From: Laura Gibbons
Sent: 26 April 2019 14:18
To: 'Aarti O'Leary'
Cc: Martin O'Connor; Andrew Quinn; Jawsy Jabbar; Stuart Corbey; Serena Page
Subject: RE: Worthing Road, Littlehampton - Planning application Ref: LU/59/19/PL LLFA comments

I have been forwarded your comments from 18th of April 2019 in relation to surface water drainage at the site 'Land at Watermead business Park, Worthing Road, Littlehampton, BN17 6LS'. **Planning application Ref: LU/59/19/PL.**

## **Appendix E – Proposed Drainage Strategy**

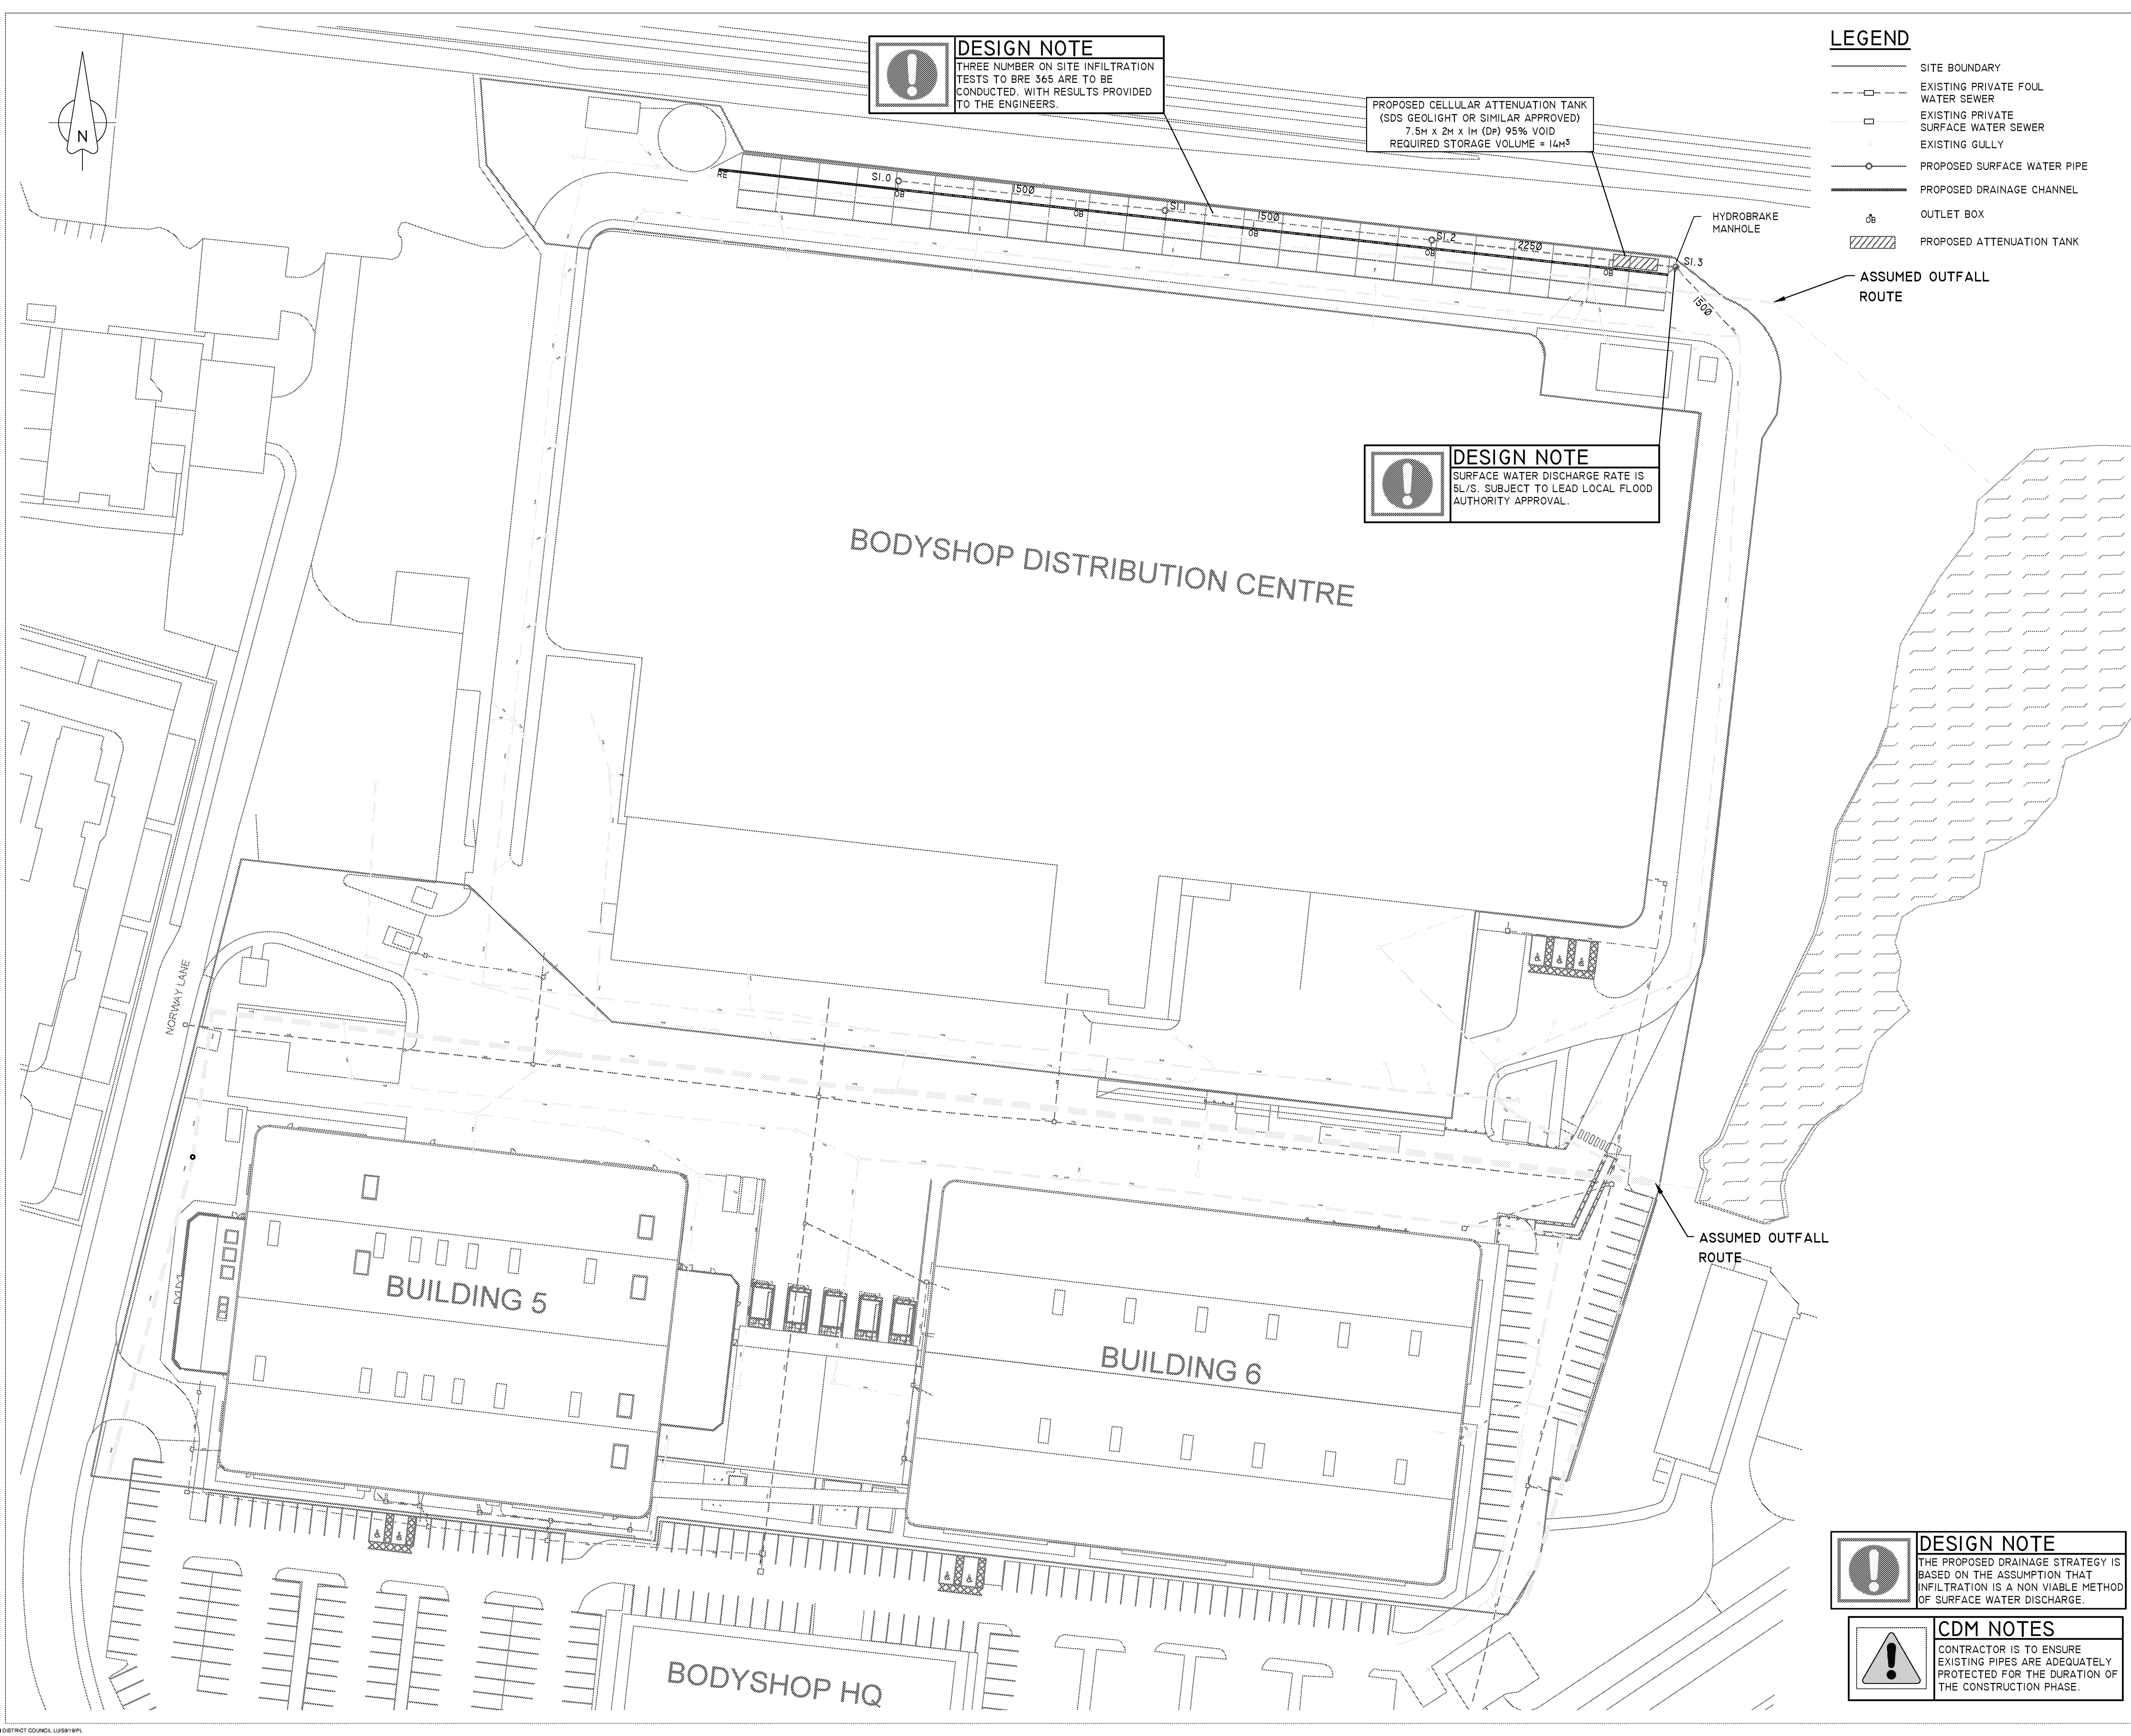
1. I would not accept a discharge of 5l/s this is far in excess of greenfield runoff rates. 2.5l/s is perfectly achievable as a discharge rate with appropriate measures provided to reduce the risk of blockage.
2. Development proposals must take account of climate change, as stated within our Local Plan Policy, NPPF and WSCC policy on surface water drainage.
3. We would accept infiltration testing at this time of year if only used to rule in or out infiltration, i.e. if it is found that infiltration does not work currently, it certainly isn't going to work in the winter and design can be progressed. However, if it is found that infiltration is feasible winter monitoring and testing will be required.
- 4-7 I will await these details.

1. The Proposals are to attenuate water and discharge at a rate of 5l/s, yet greenfield runoff rates are 0.3l/s. we would require that the proposed discharge rates are reduced to 2.5l/s, this rate is achievable without increasing the risk of blockage to unacceptable level. A hydrobrake with a minimum sump depth of 300mm should be provided. With a proposed discharge rate of 2.5l/s this will result in a reduction of the orifice of the hydrobrake, given the close proximity of landscape areas, there is an increased risk of blockages to the control device, hence the proposal of 5l/s. we would kindly ask you to reconsider given the information we have provided.

4. The proposed attenuation tank appears to clash with the existing surface water drainage network. Clarification must be provided as to how the two will interact. Invert levels and cover levels of the proposed drainage must be provided. Invert levels can be provided and will be added to drawing to prove no clash.

5. Will the proposed drainage channel have a sump? Yes there will be a sump within the outlet boxes as indicated on the plan.
6. Construction Detail drawings need to be provided. To be provided
